From: Franklin, Richard [REDACTED]
Sent: 18 December 2017 [REDACTED]
To: 'bdaines@eceplanning.com'
Cc: Richard Temple; Planning.Responses; 'stephen.gee@westsussex.gov.uk'; Planning SE; Bowie, David
Subject: (HE ref #4116 / 79420): WA/73/17/OUT: Land East of Wandleys Lane, Fontwell - Transport documents

Traffic Flow Diagrams (HE comment 3 / PBA response 3)

Junction modelling

Project:	ITB11324 Walberton
Title:	A27 / A29 signals (Fontwell Eastern Rbt)
Location:	
File name:	2031 A27_A29 Fontwell E Rbt.lsg3x
Author:	AL
Company:	i-T
Address:	
Notes:	To Systra dwg 103800_D007

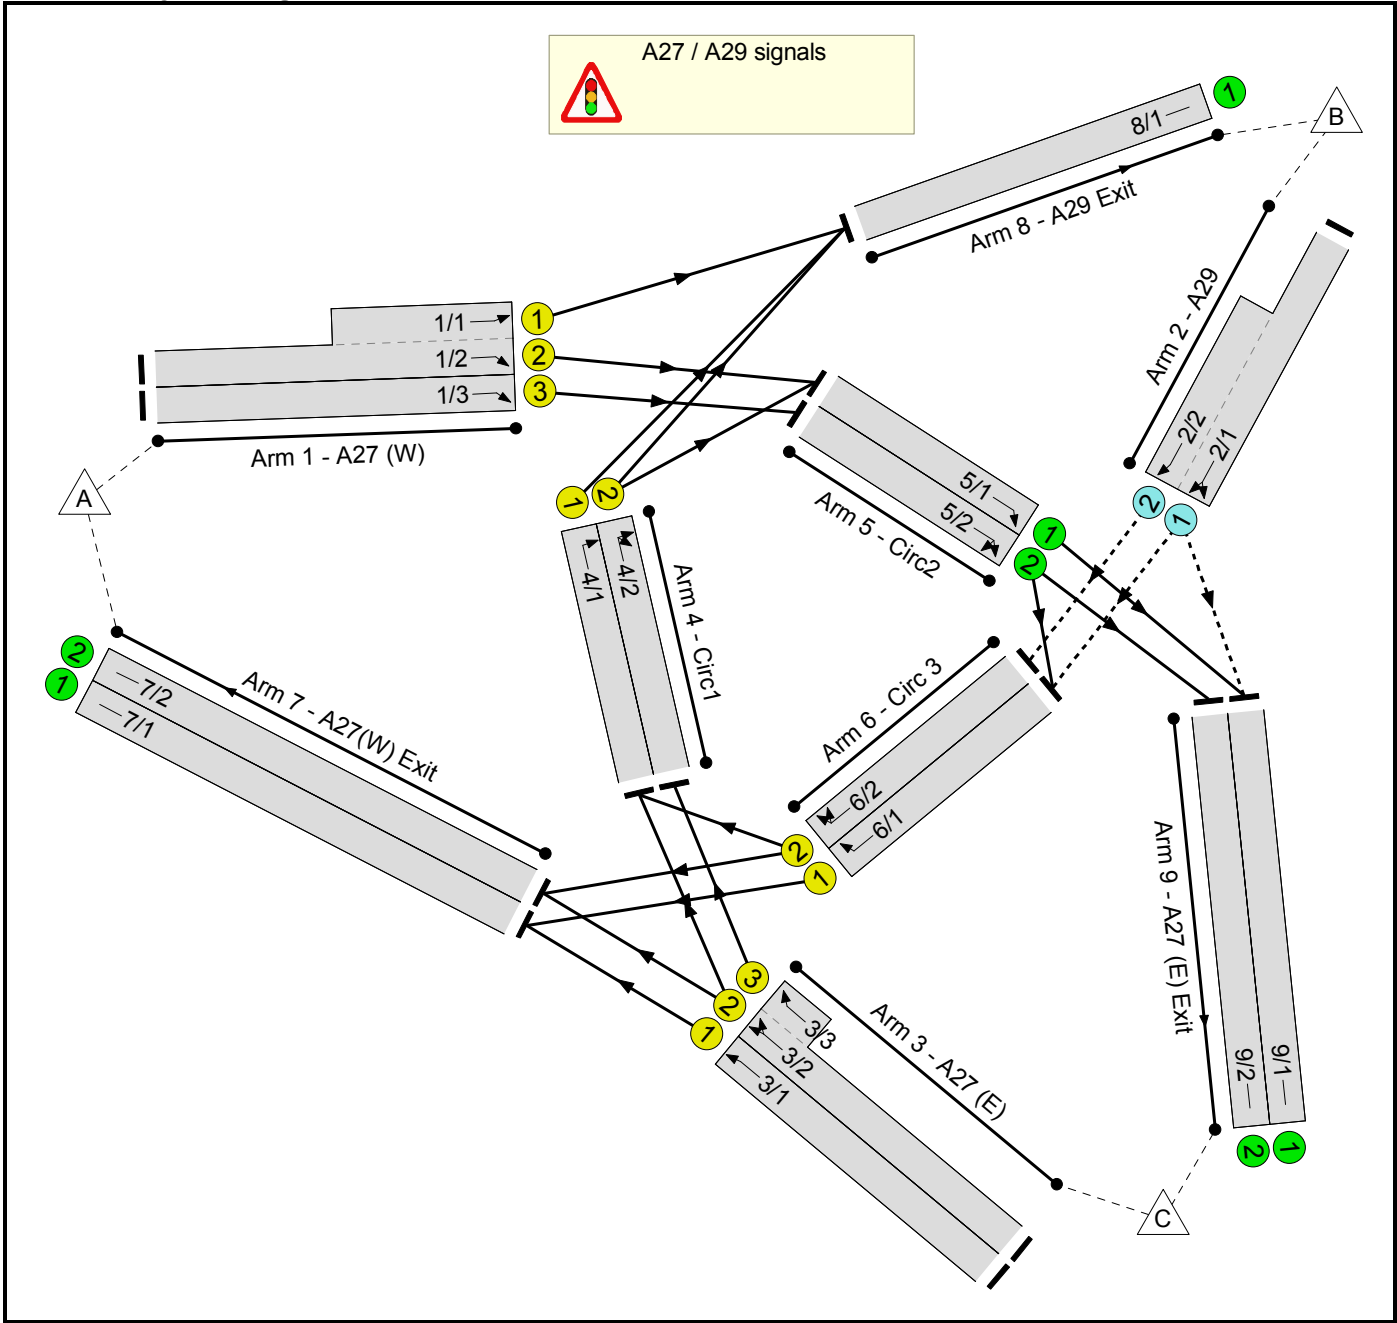
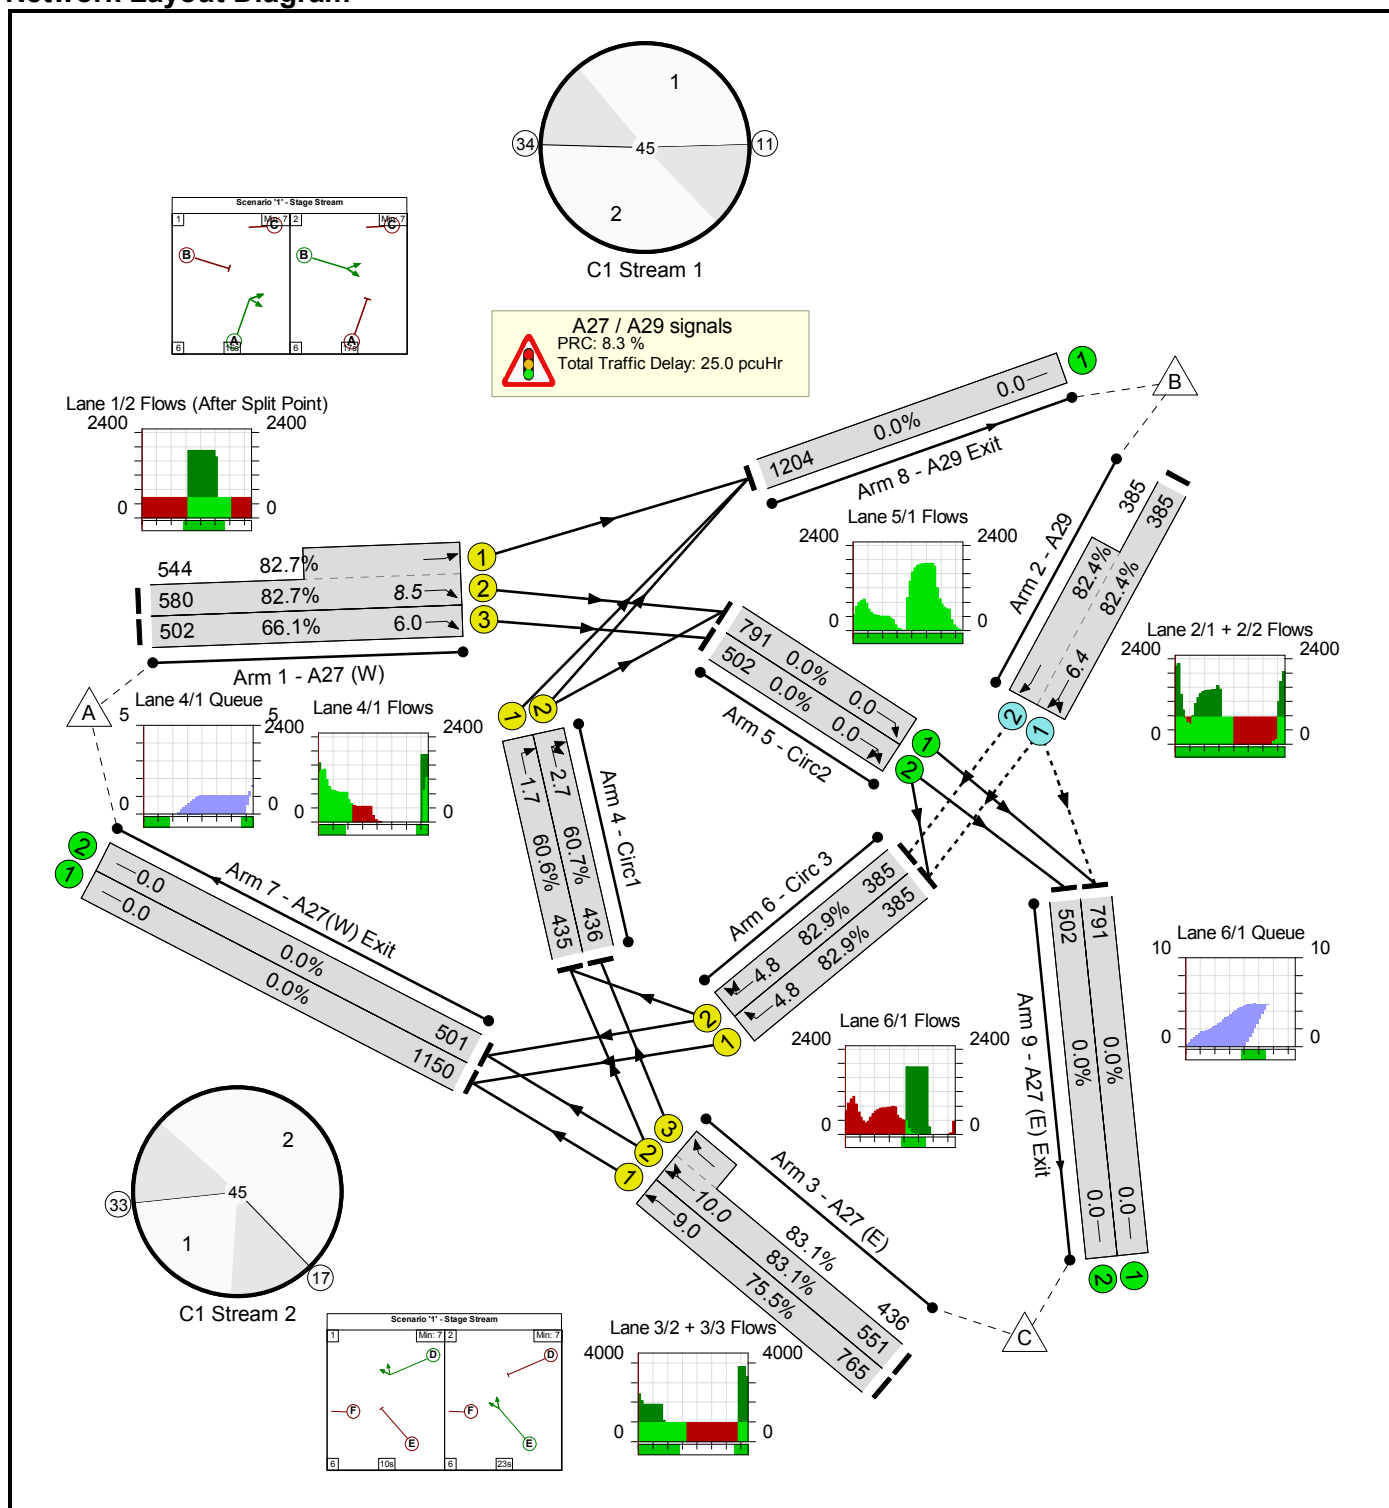
- With regard to the geometry at the Fontwell East Roundabout, as per the Fontwell West Roundabout, the refined model for the Fontwell East roundabout that was agreed for the land East of Tye Lane development is attached, which can be used to assess the impact of the Wandleys’ Lane development. As part of this, we would like to see a sensitivity test where the flows associated with Land East of Tye Lane are used.

Drawing Issue Status					
INDICATIVE - FOR INFORMATION					
LAND EAST OF WANDLEYS LANE A27 / A29 WEST ROUNDABOUT JUNCTION GEOMETRY					
Client					
WELBECK STRATEGIC LAND II LLP					
Date of 1st Issue 29.09.17		Designed JHJ	Drawn MJB		
A3 Scale 1:500		Checked GH	Approved GH

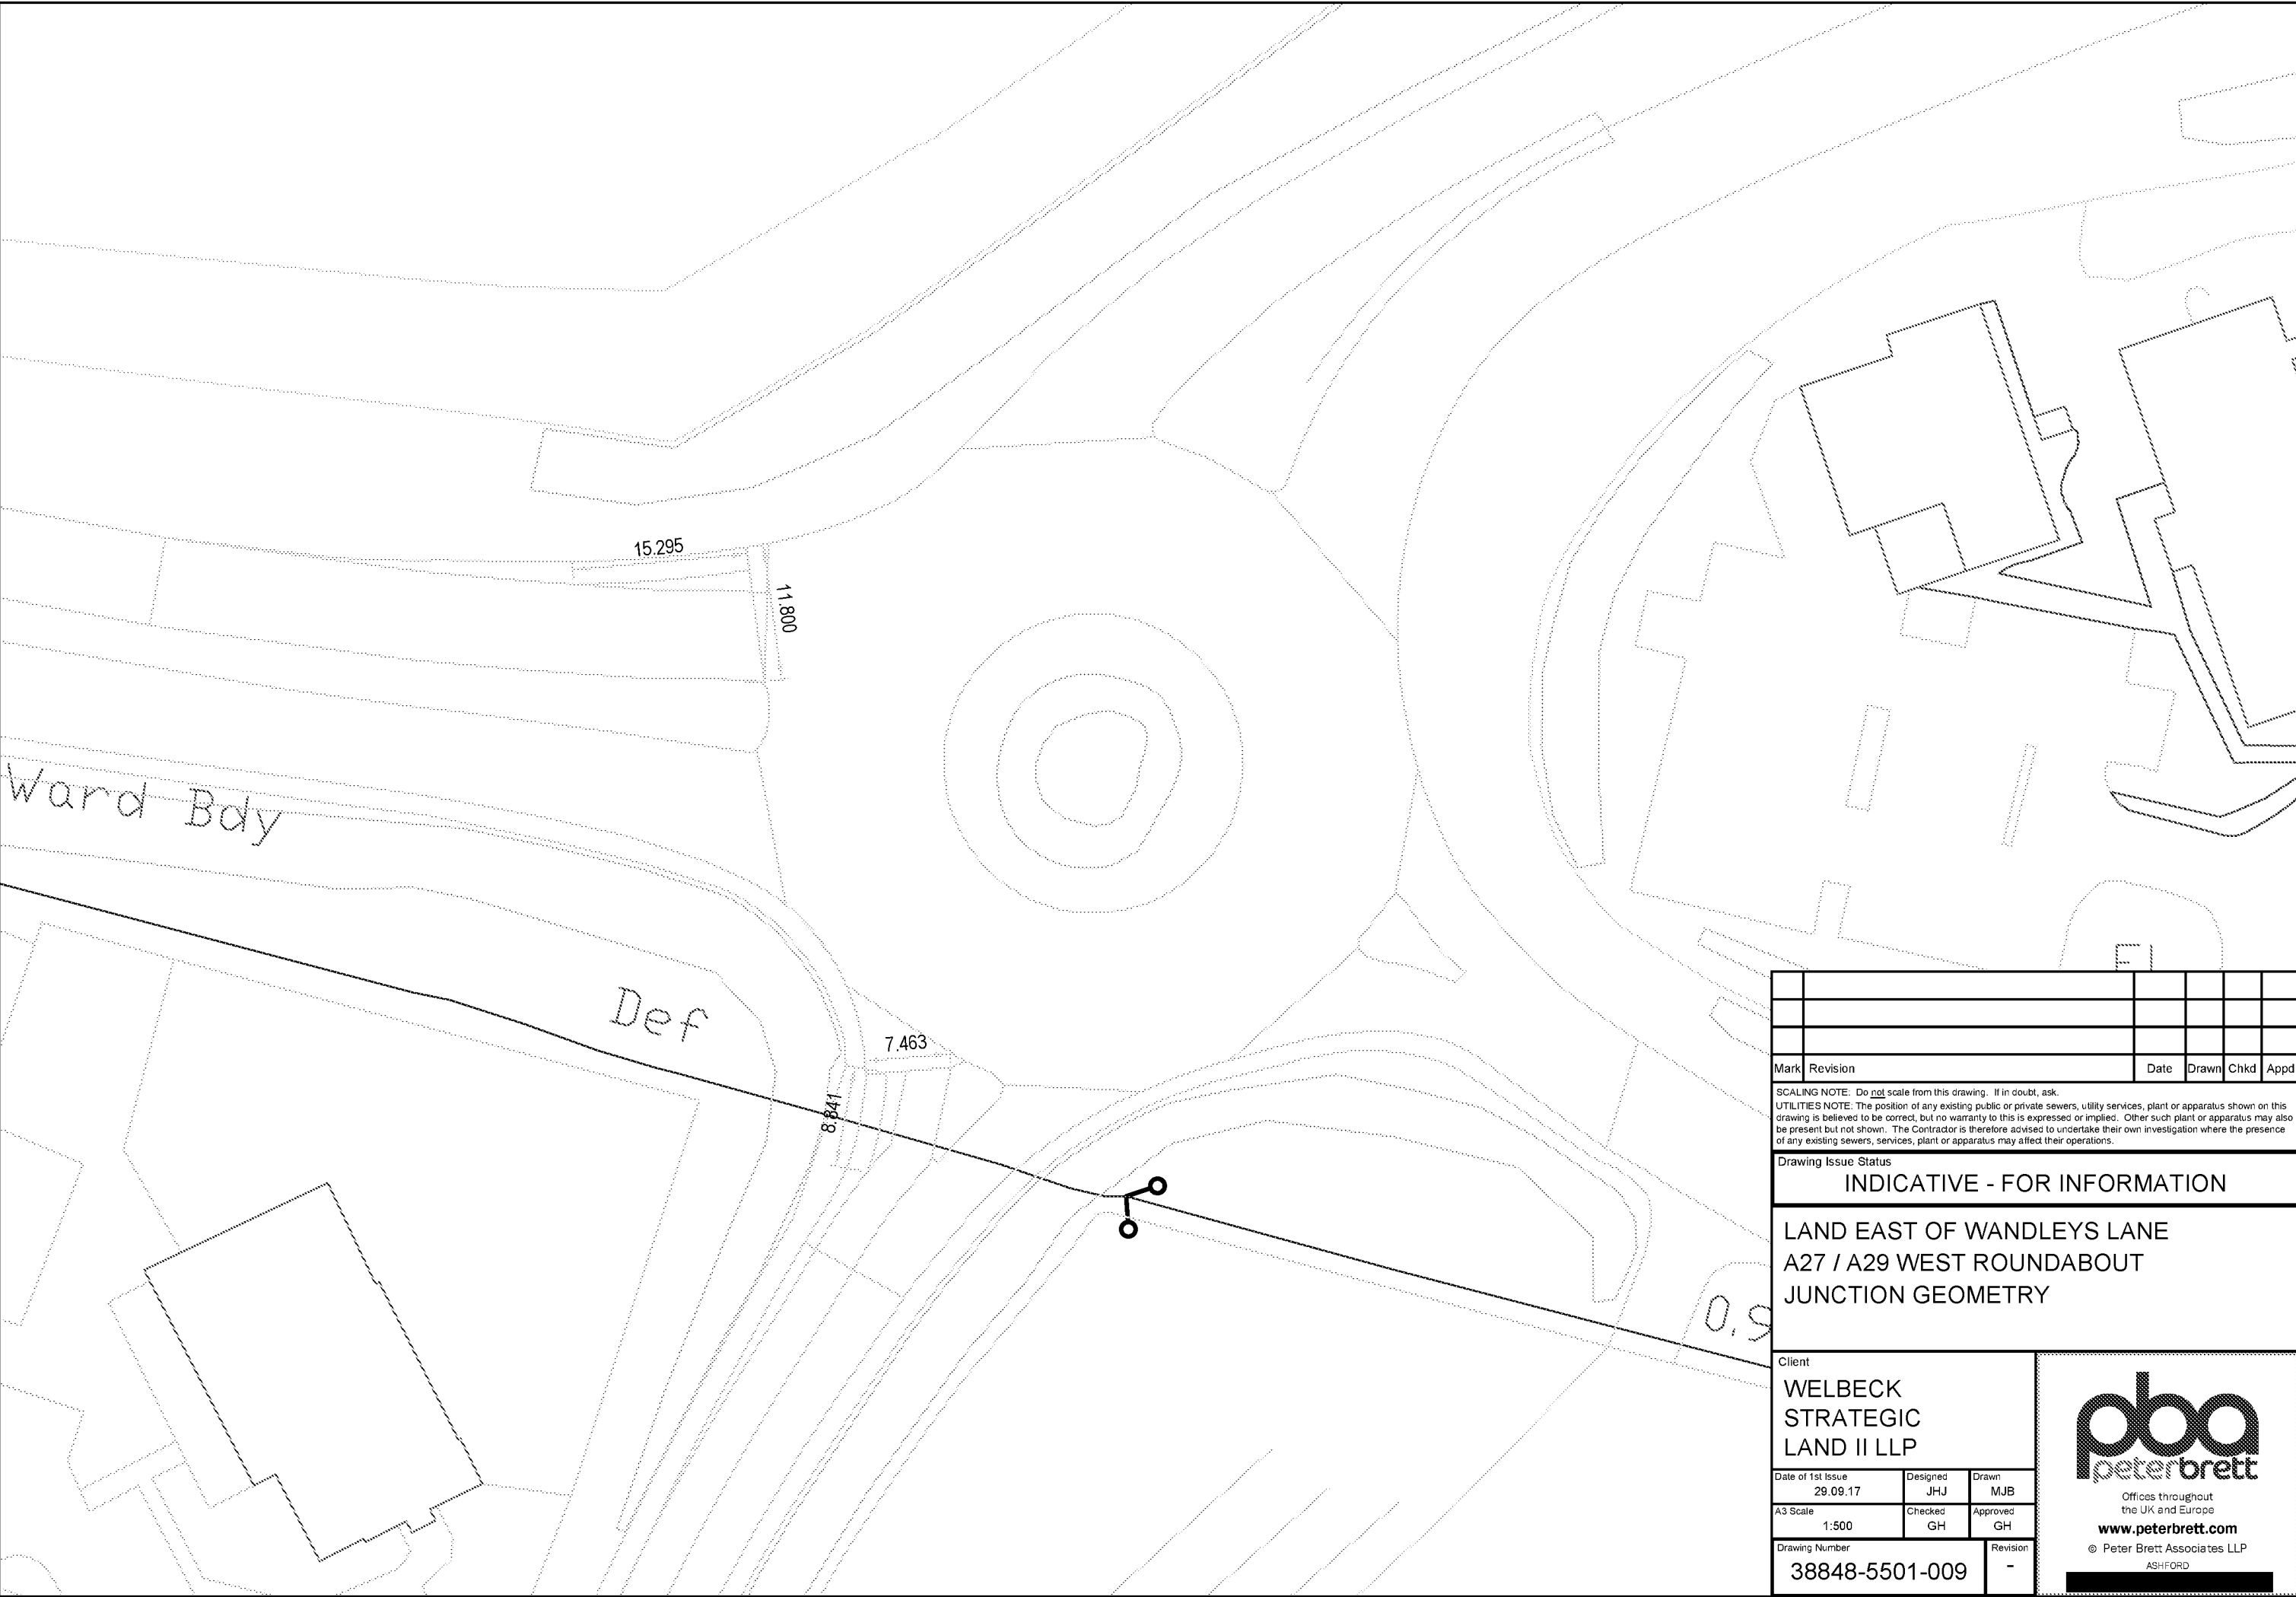
- In trying to clarify the above, we compared the traffic flow diagrams with the modelling for the Fontwell West roundabout and noted the following differences – please can this be clarified?

- With regard to the modelling, we note the approach adopted and are satisfied with the principle of the flows used. However, Highways England is concerned that the LINSIG model used does not accurately model the junction (see our previous comments on geometry). The LINSIG model provided was used to determine the strategic impact on the junction to give an indication of any impacts of major significance that would render the emerging Arun Local Plan unsound. It is accepted that this model is basic and would need detailed refinement at the application stage, and accordingly as the Wandley’s Lane development is in that position and outside of the emerging Local Plan allocations, it would be appropriate to refine the strategic model in order to provide a robust assessment of this development’s impact. As such, we are providing the refined model for the Fontwell West roundabout that was agreed for the Land East of Tye Lane development as attached, which can be used to assess the impact of the Wandley’s Lane development, although we would advise that you review it as acceptable for your purposes. As part of this, we would like to see a sensitivity test where the Land East of Tye Lane flows and mitigation are included.
